**Final Acceptance Punchlist**  
**El Paso County – Department of Public Works - Stormwater Section**

Project Name:	Redtail Ranch
EDARP Filing Number(s):	SF1821
ESQCP Number:	ESQ1932
Attendees:	DPW SW: Molly Layshock, Mikayla Hartford, Glenn Reese DPW Dev Services: Developer:
Date of Walk-Thru:	05/18/2023
Walk-Thru Number:	1 <sup>st</sup> FA walk

DESIGNED BY	MAW	SCALE	DATE	07-03-18
DRAWN BY	MAW	(H) 1" = 30'	SHEET	9 OF 10
CHECKED BY	(V) 1" = N/A	JOB NO.	2525.00

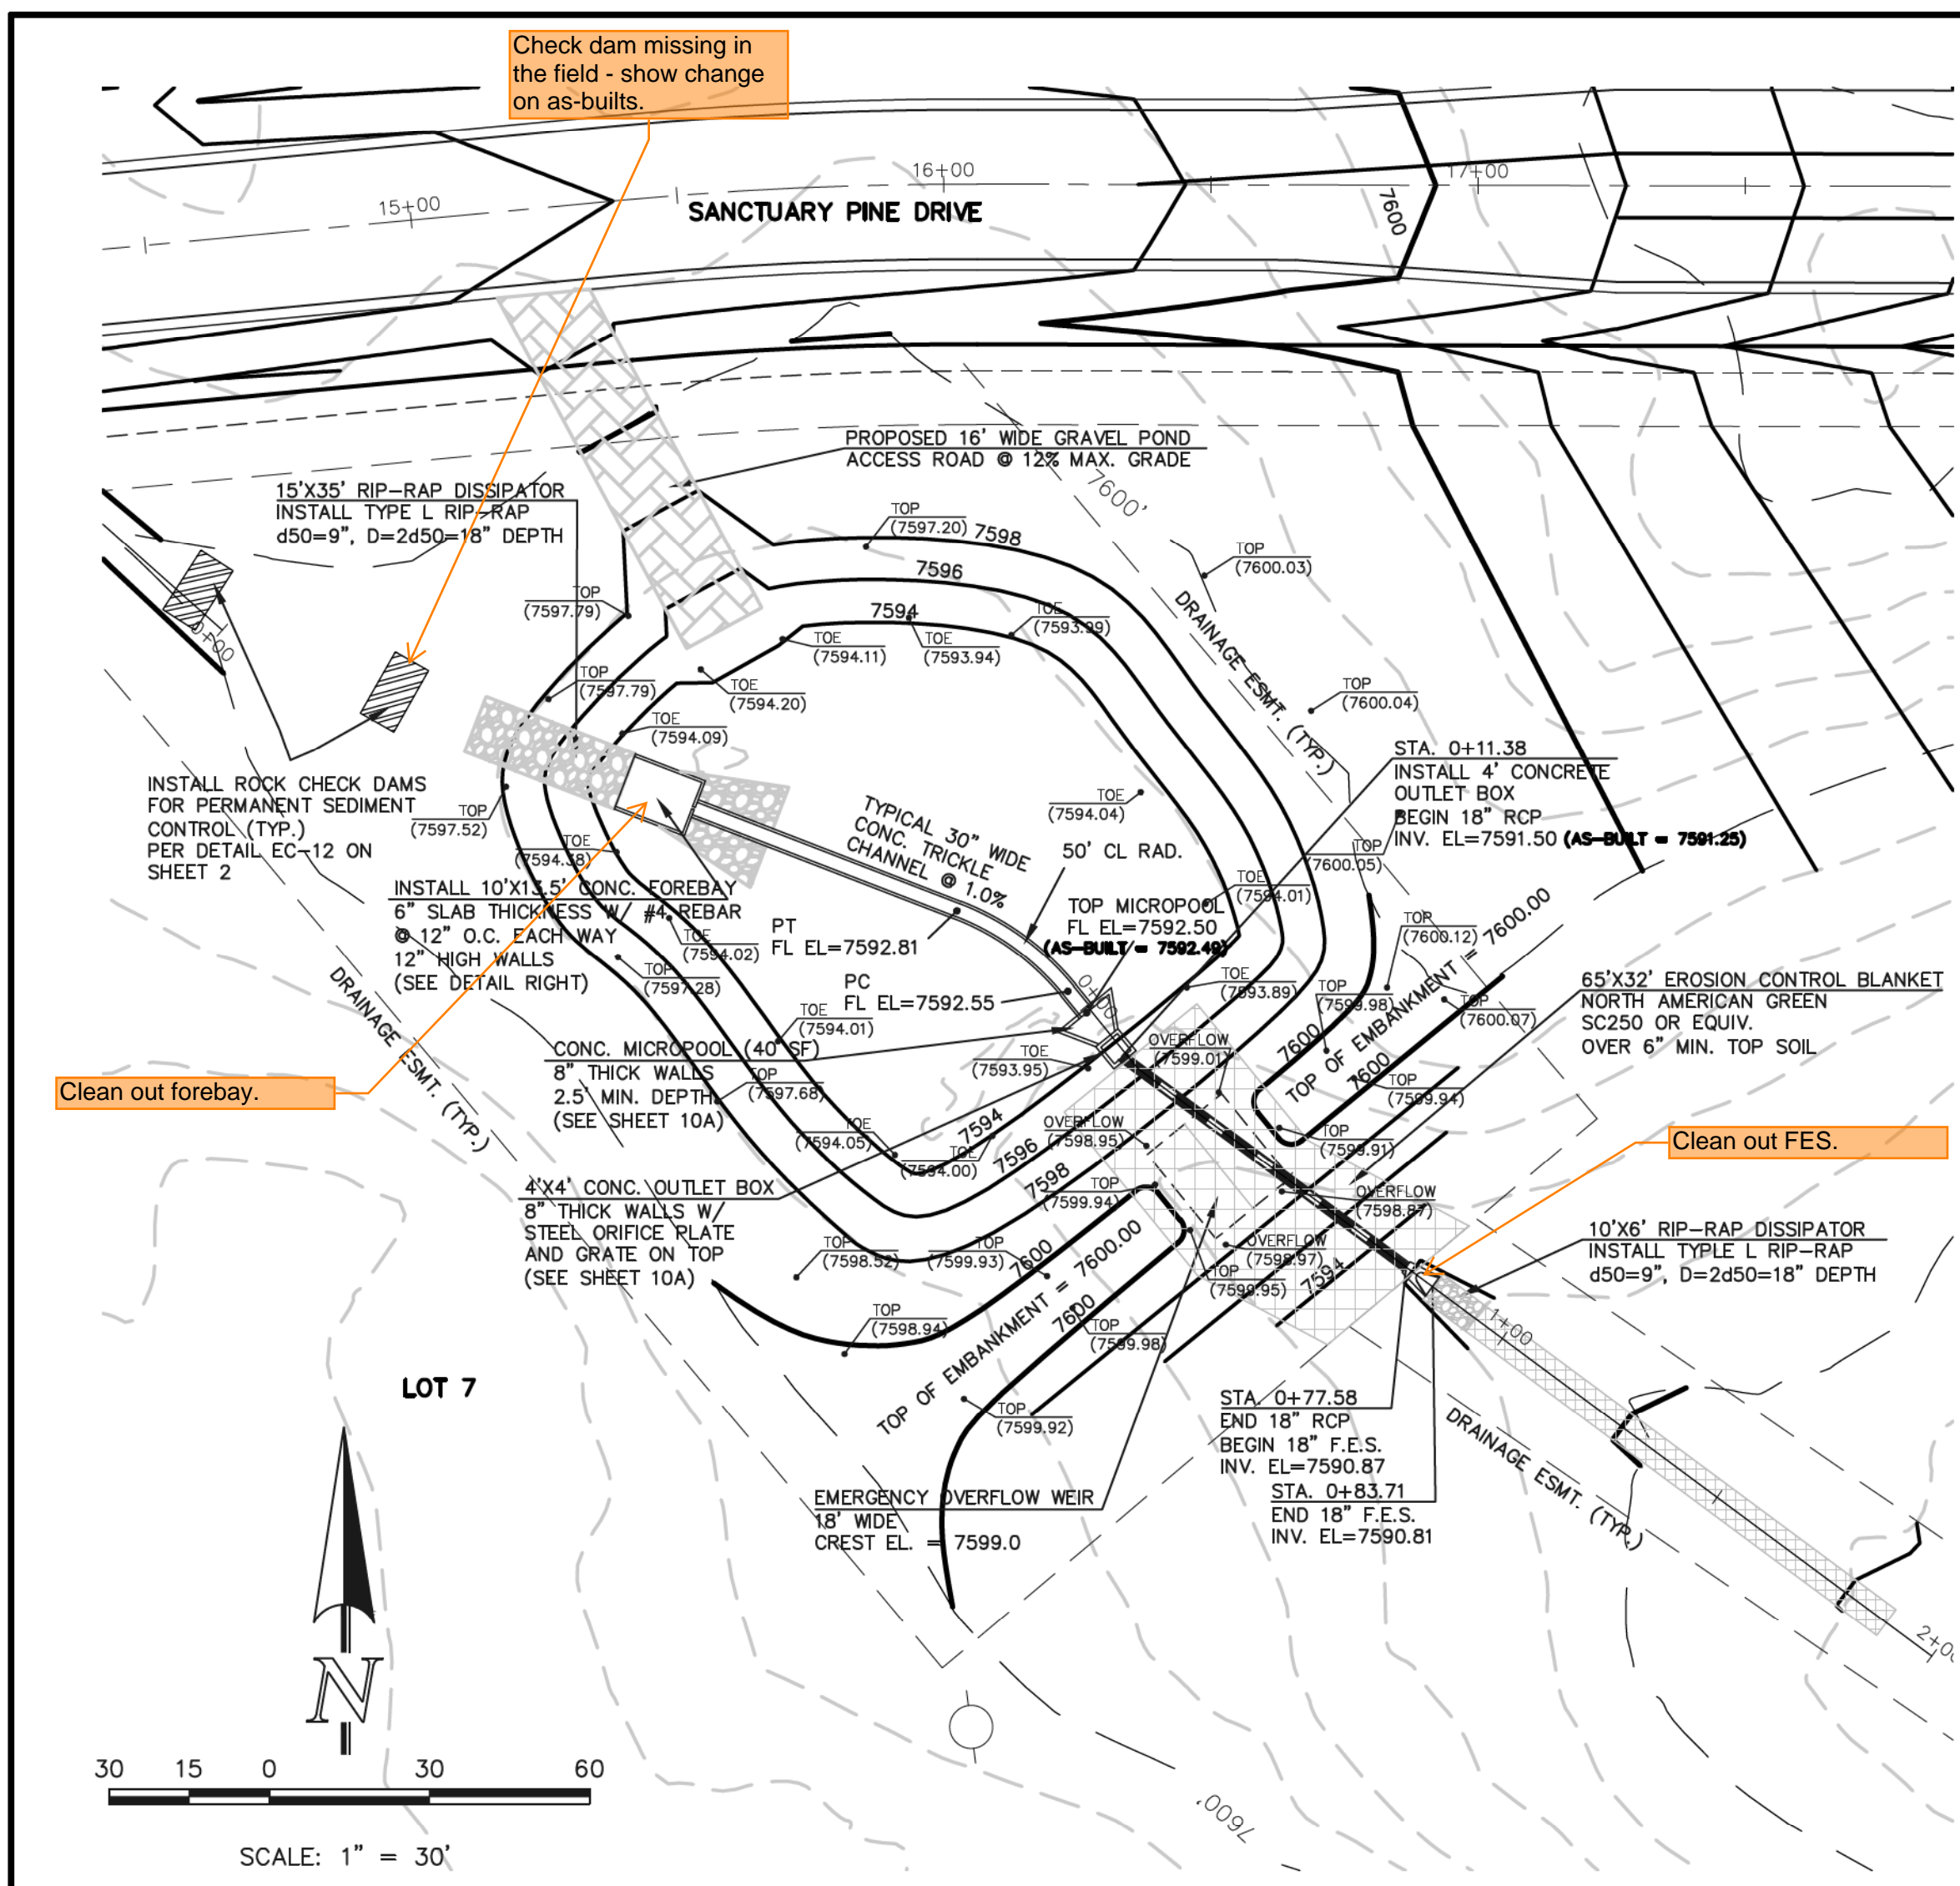
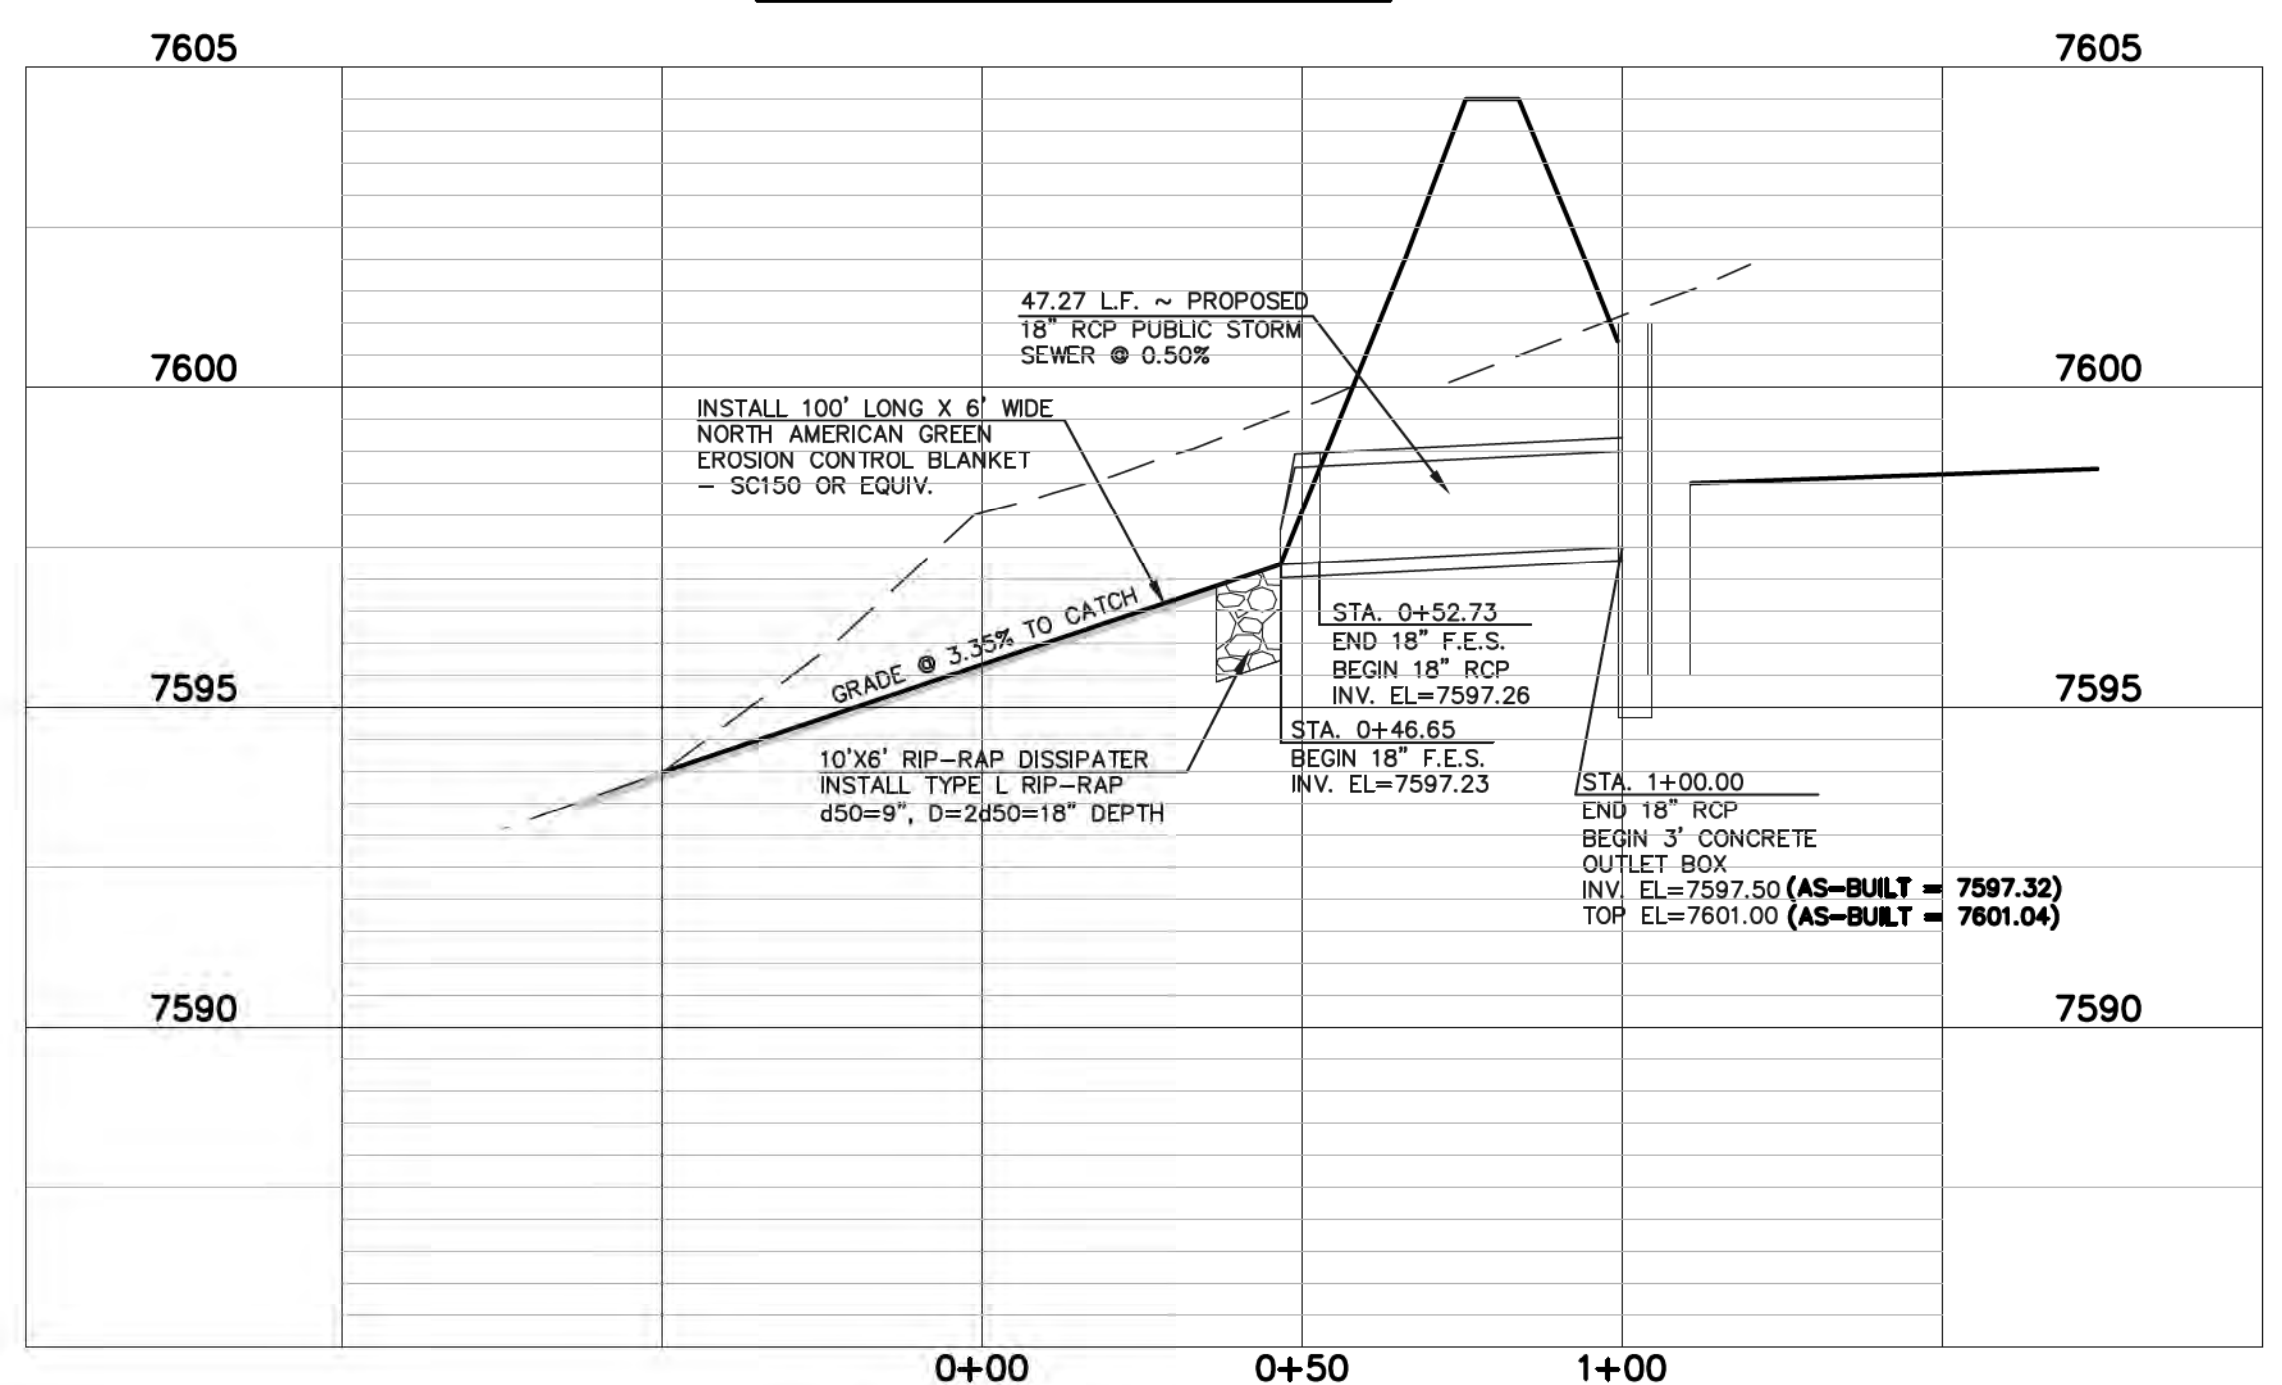
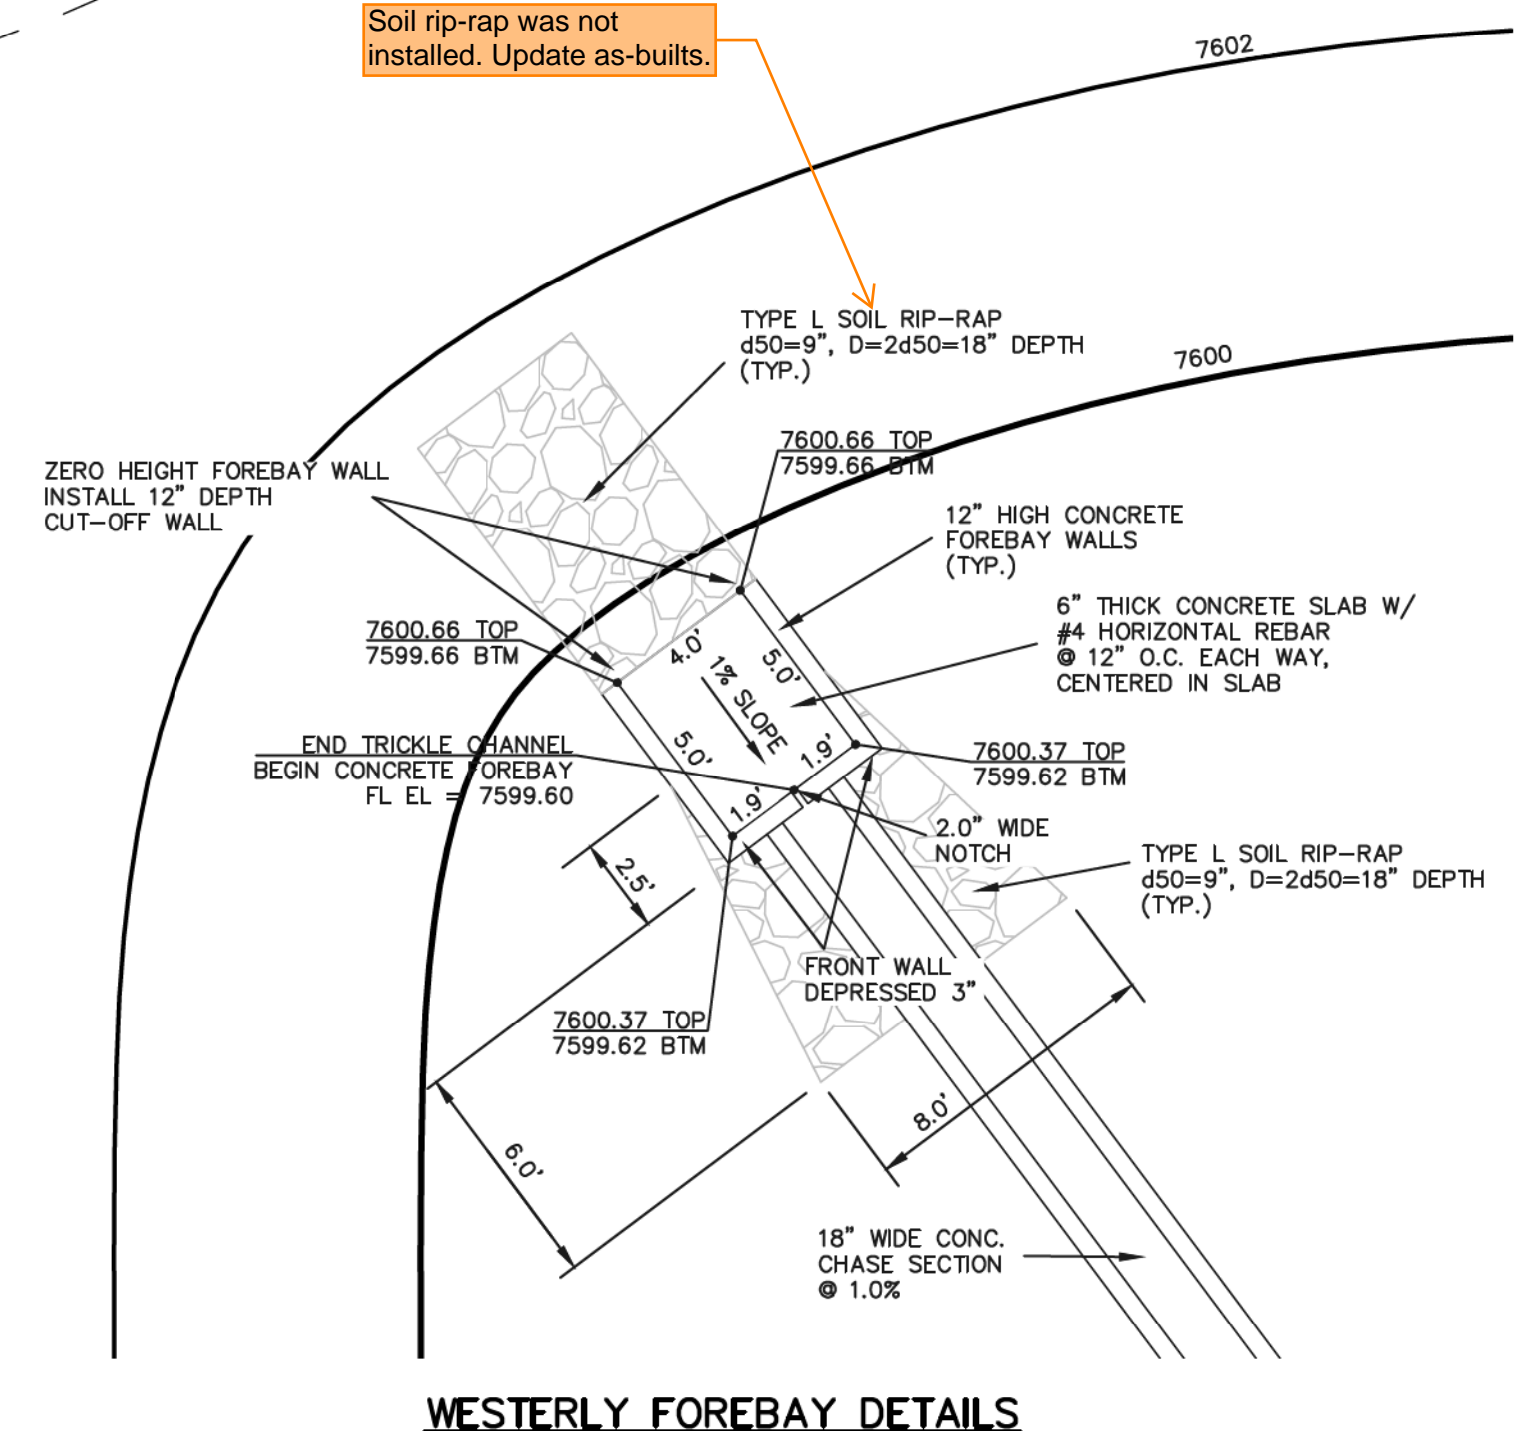
- Major comment: During the FA Walk, Basin 2 was fully drained but Basin 1 had about 18"-24" of standing water. The outlet structure was not clogged but the system was not fully draining (See photo 5). The pond bottom, trickle channel, and forebays could not be fully inspected because they were covered. The pond's drainage issues must be resolved before FA and pond bottom stabilization must be achieved.

- 19"x60" outlet box orifice plate (sheet 9A of 10) measures 60"x60" in the field. Reflect this change on the as-builts
- Adjust grading at check dams upstream of easterly rundown for positive drainage

- Update as-builts to change soil riprap called out on sheet 10 of the plans to be riprap reflecting the change observed in the field. (See comments on as-builts)

- Remove temporary control measures along 24" wide concrete trickle channel
- Wrong well screen is installed in the field. Install proper well screen, diamond well screen is not permitted
